File No: NTH24/00244/007  
Your Ref: SSD-65595459

**Revised Response to Submissions (SSD-65595459), Hunter Indoor Sports Centre, Lot 2380 DP755247, Lot 2379 DP755247, Lot 2378 DP755247 and Lot 2377 DP755247, 2 Monash Road and 24 Wallarah Road New Lambton**

DRAWING TITLE  
GENERAL ARRANGEMENT PLAN

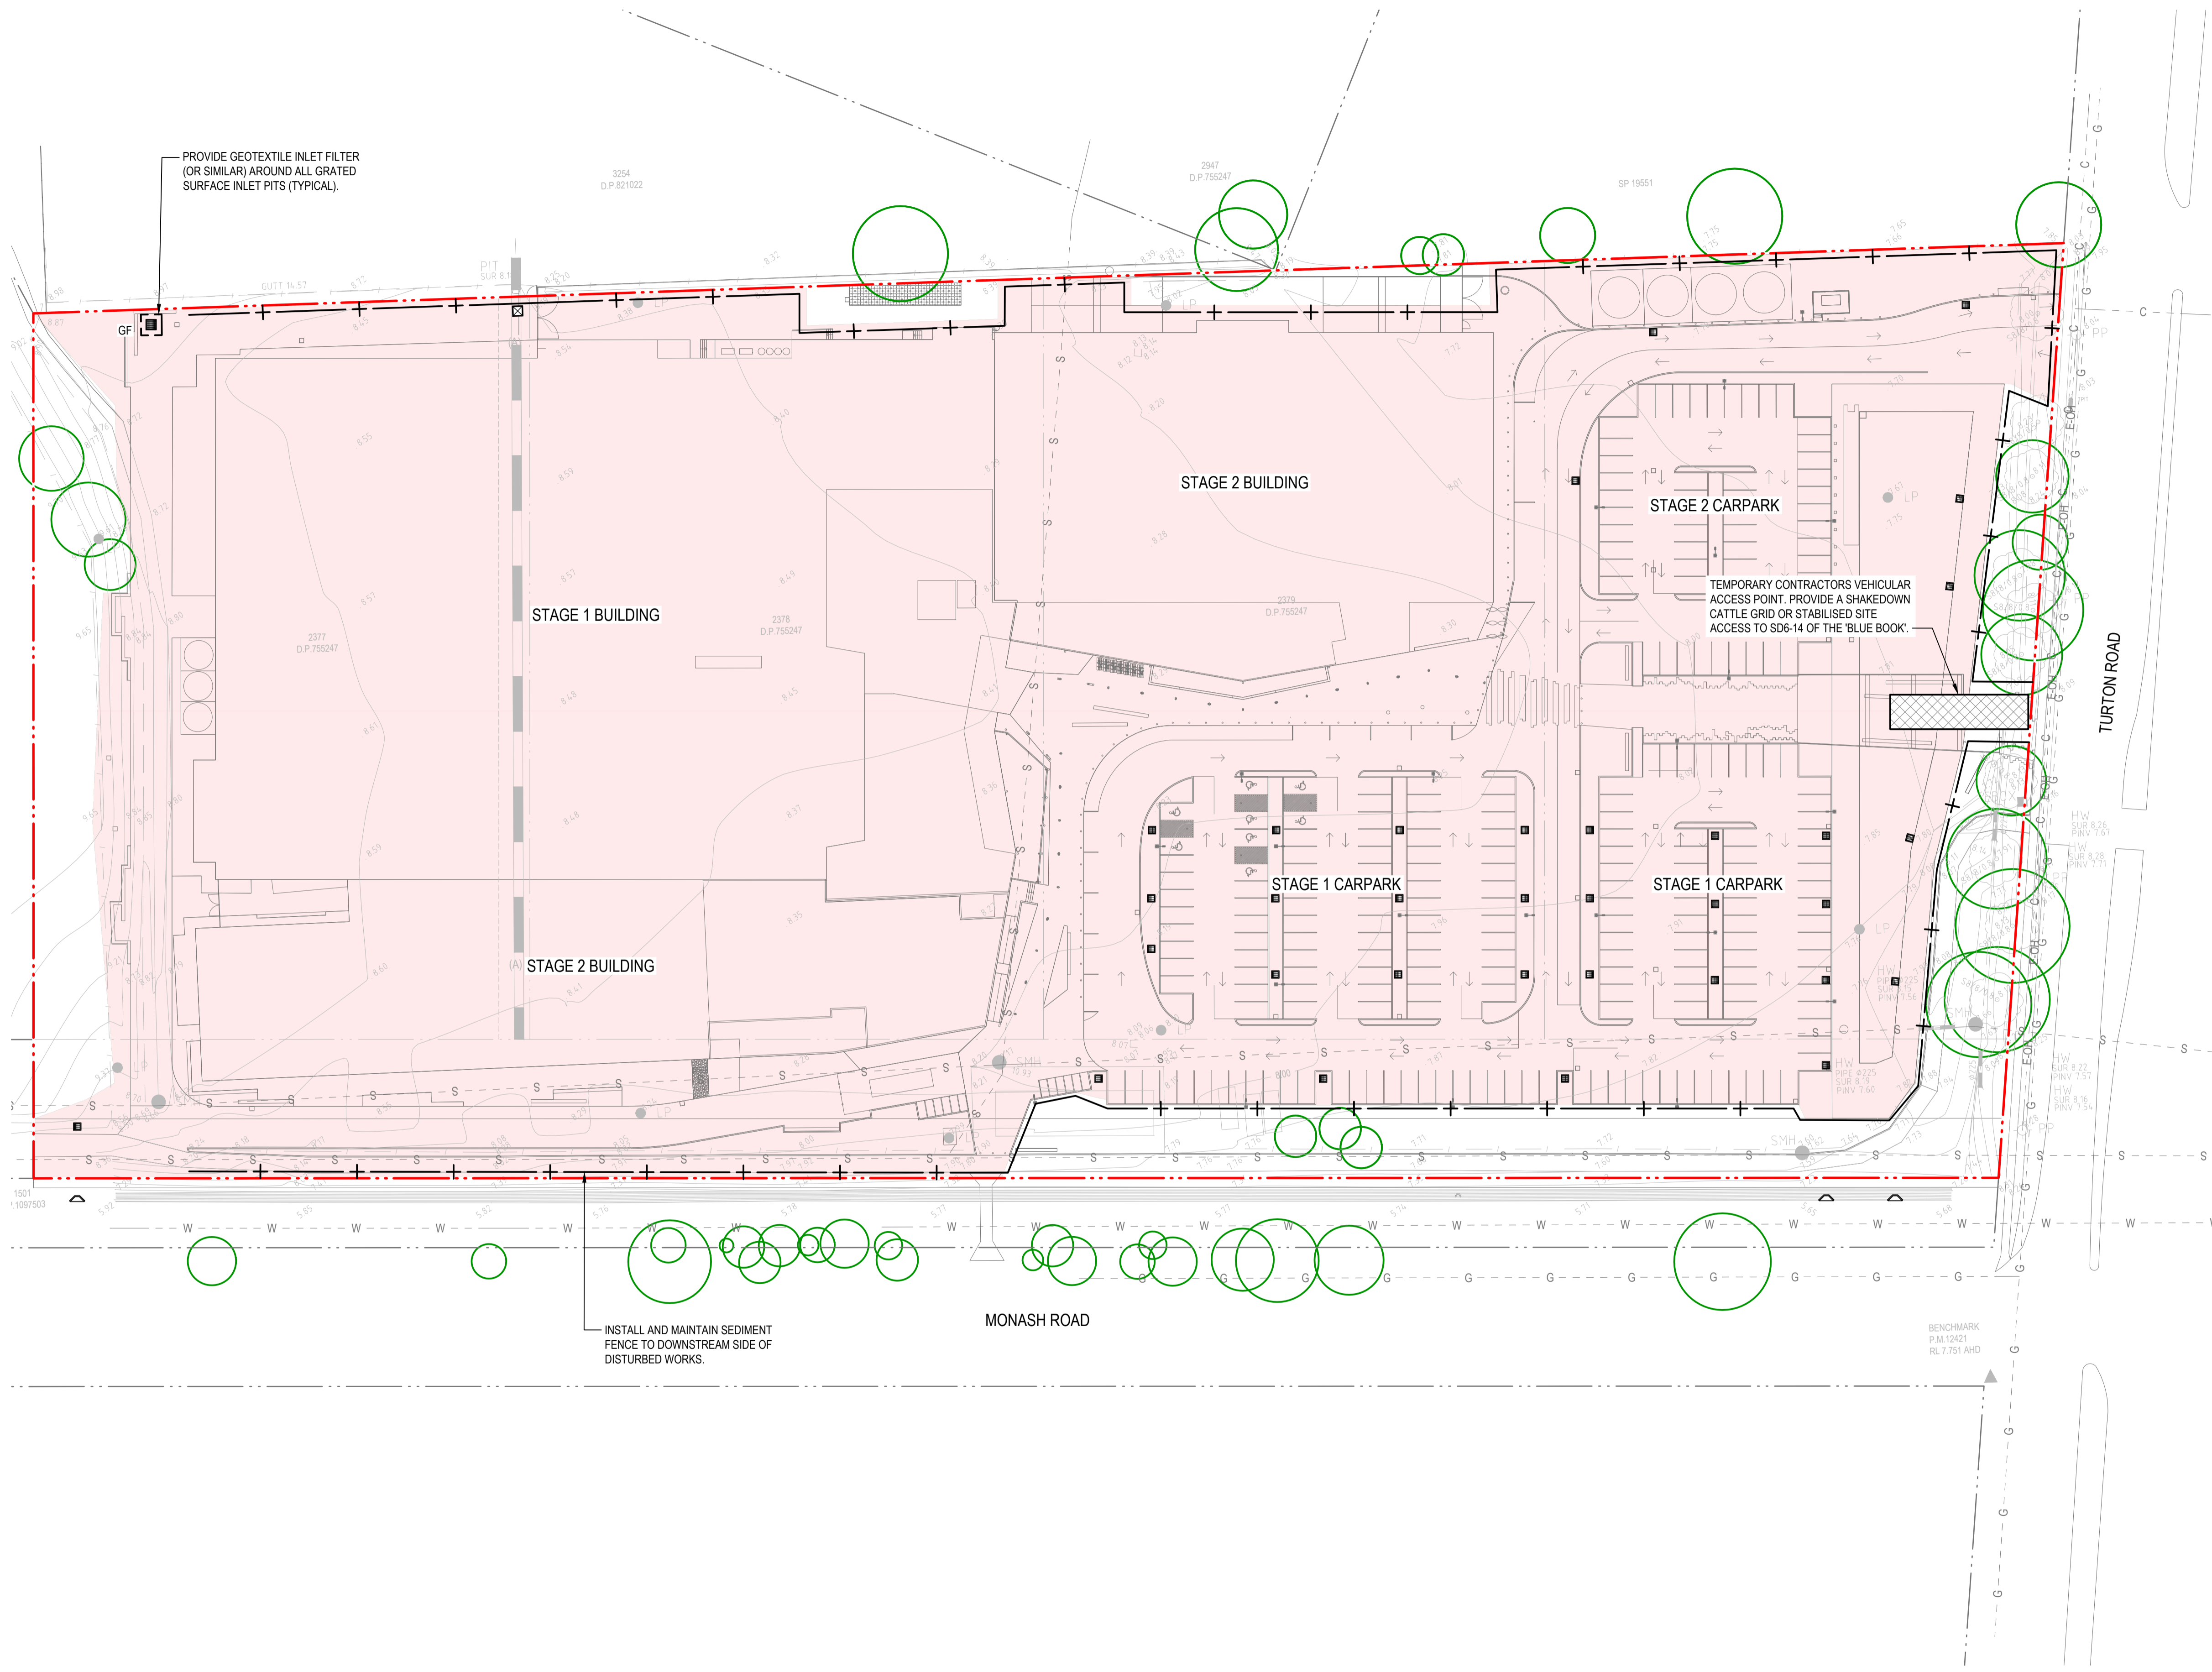
The plans should be updated to include the following;

- a. Remove any references to a left turn lane into the site access.
- b. Amendment of the 'No Stopping' signs and additional added as per sketch below.

Alternatively, use of the NS1 line marking may be more practical and reduce the number of no stopping signs required.

- c. The small painted island at the driveway entrance impacts the on-road cycle area and should be pushed back into the driveway layback area.
- d. A left only sign and pavement arrow should be installed in the driveway layback for exiting traffic.
- e. No U-turn signage should be installed on the central median at the intersection with Monash Road to deter this movement.
